CAPITAL CORPORATION

AXIS: STAGE 1A

ACCESS REVIEW

7th May 2013

TYPICAL LEVELS

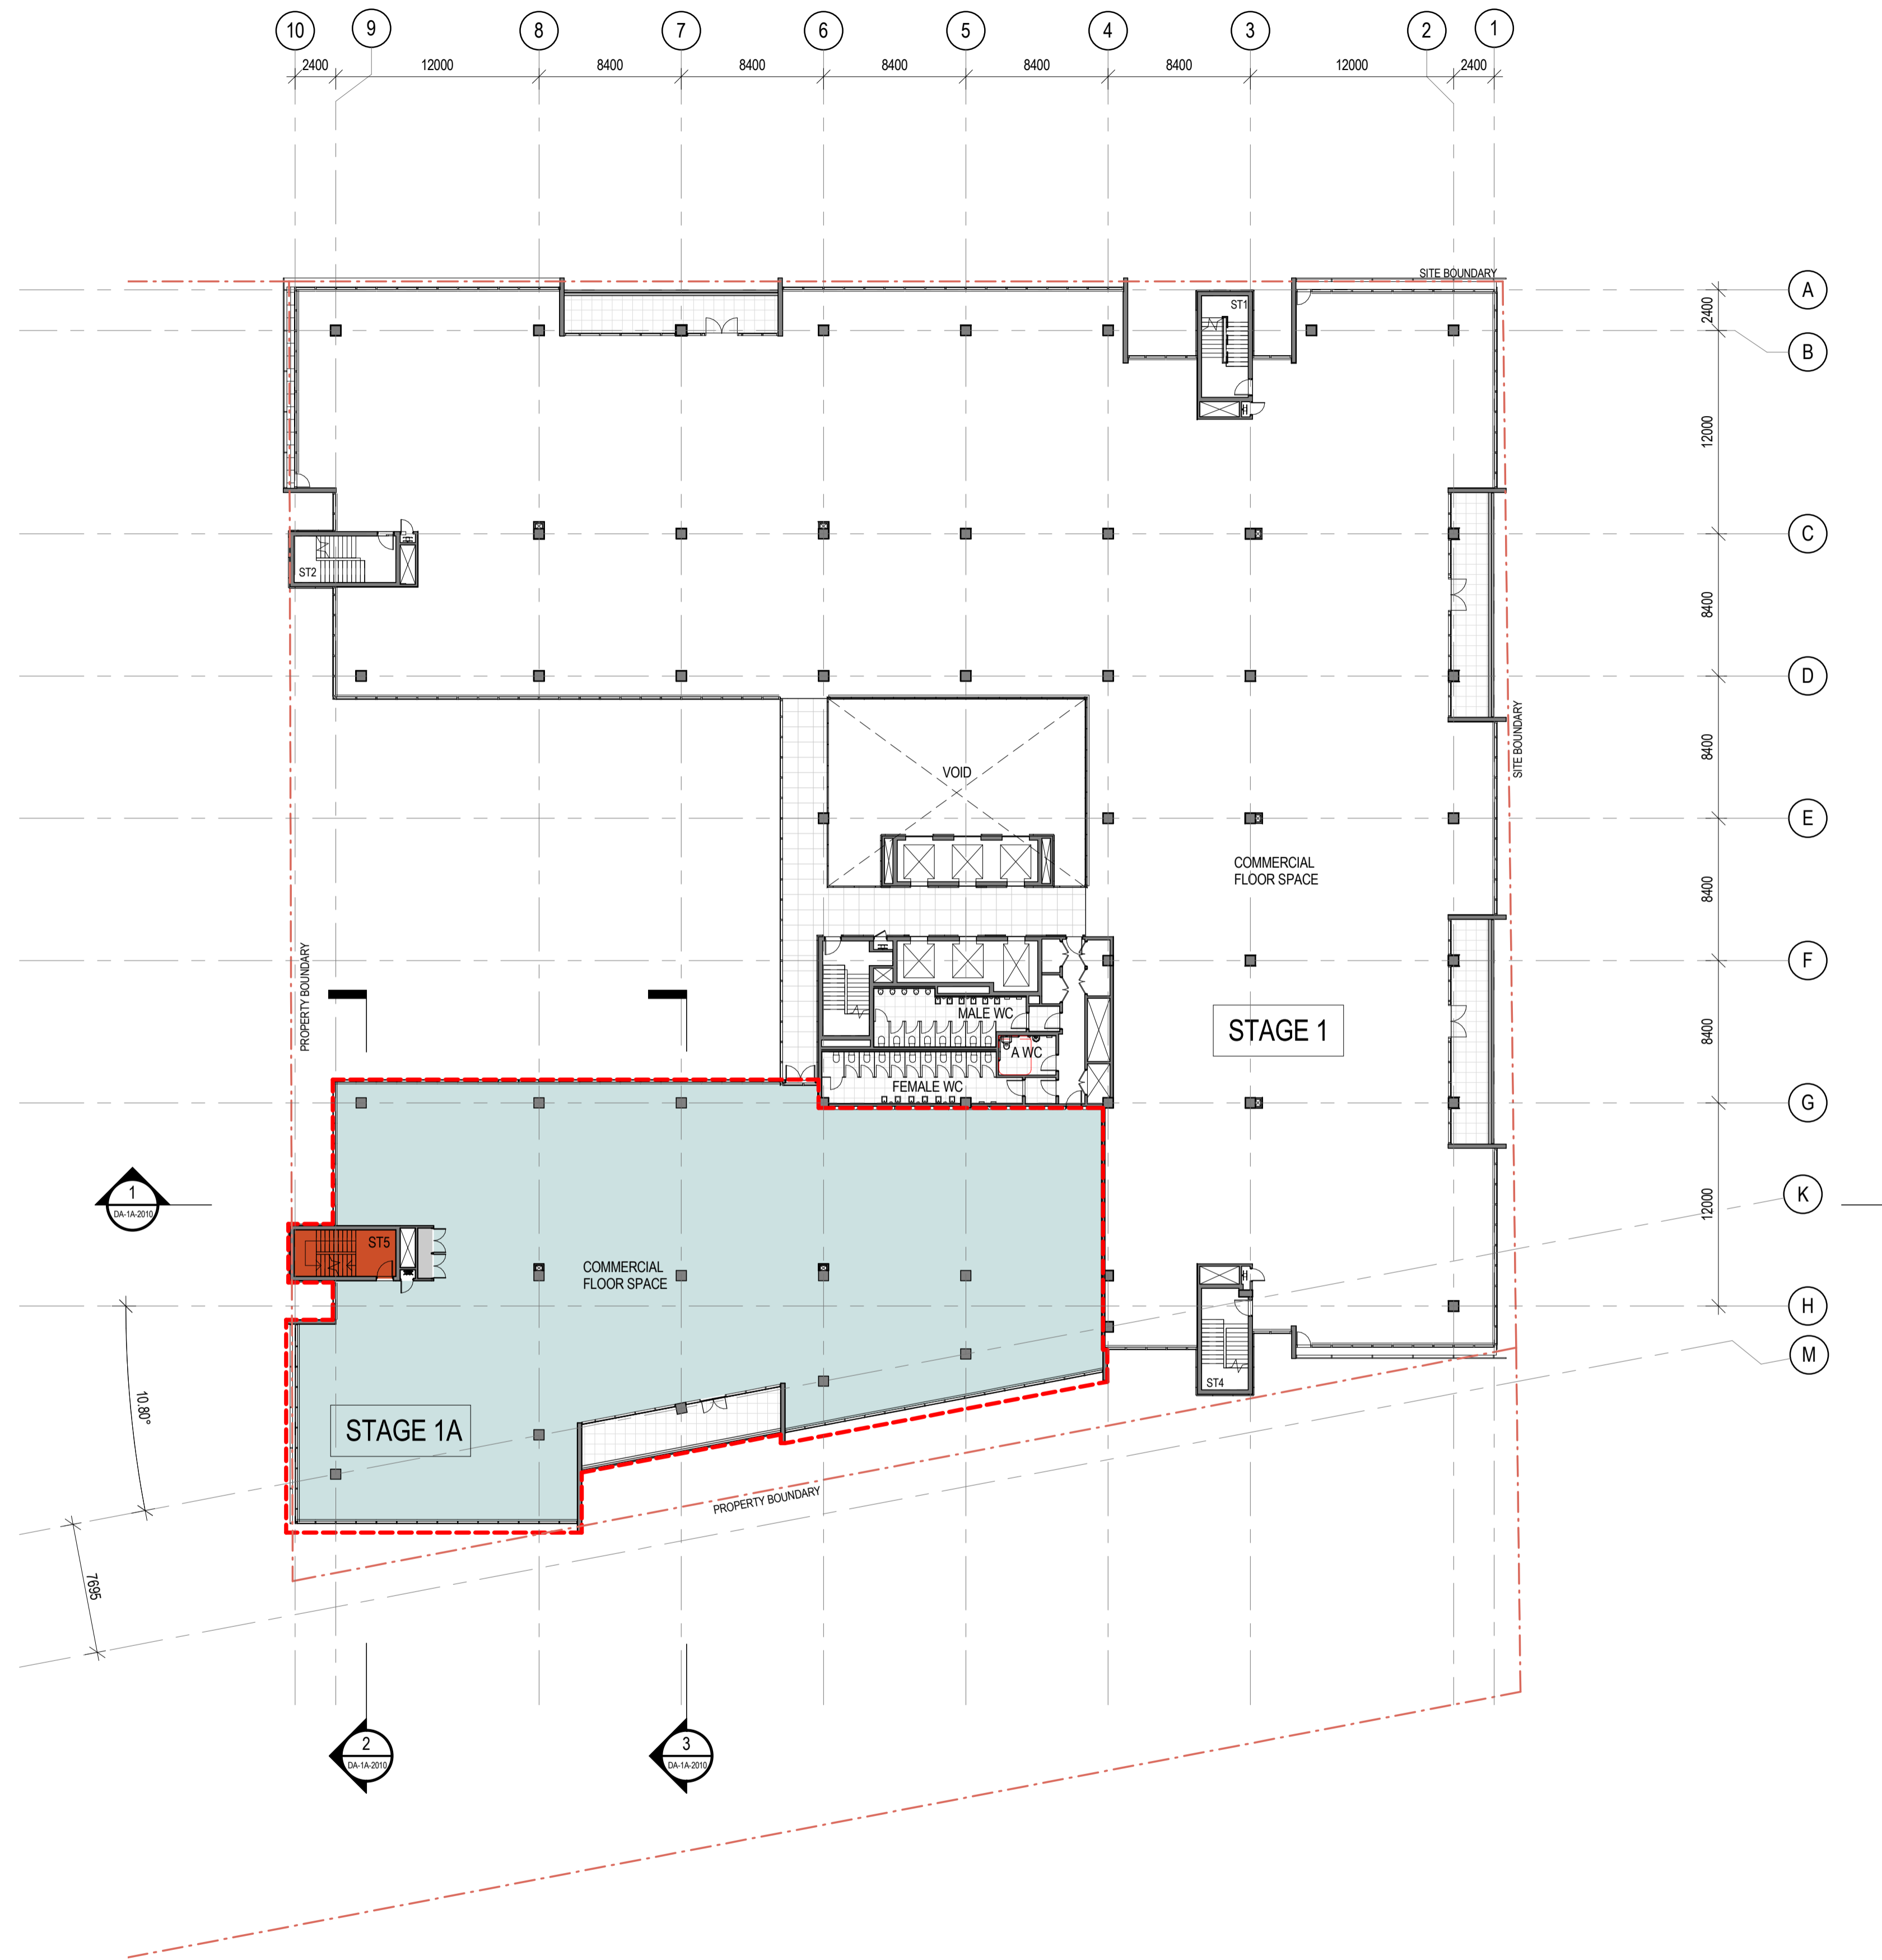
From the Stage 1 lift lobby, there is an accessible path of travel via the atrium lobby area to Stage 1A. The dual-hinged entry door appears to have 820mm clear widths. Modification is required to ensure compliance with AS1428.1:2009.

The commercial floors have appropriate circulation areas to allow wheelchair manoeuvrability in accordance with the SOPA guidelines. There are suitable clearances to allow a person in a wheelchair to perform 180° turns compliant with AS1428.1:2009 and the DDA Premises Standards. There are appropriate clearances to two wheelchair users to pass one another in the opposite direction compliant with the DDA Premises Standards.

The single leaf entry door has an appropriate 850mm clear width compliant with AS1428.1:2009 and the DDA Premises Standards. The door currently has 430mm internal latch side clearance which will need to be enlarged to ensure suitable latch side clearance compliant with AS1428.1:2009.

- (i) Ensure hinged entry door leading to sanitary facilities from Stage 1A has 850mm clear widths (920mm door leaf) compliant with AS1428.1:2009.

There currently does not appear to be any fire refuge areas within the emergency stair well.

- (i) Handrails within stairs to be compliant with AS1428.1, clause 12.
- (ii) Provide fire refuge areas within emergency egress stair wells. The space shall be 1300mm x 800mm outside the egress route. Provide an emergency communication device at this area.
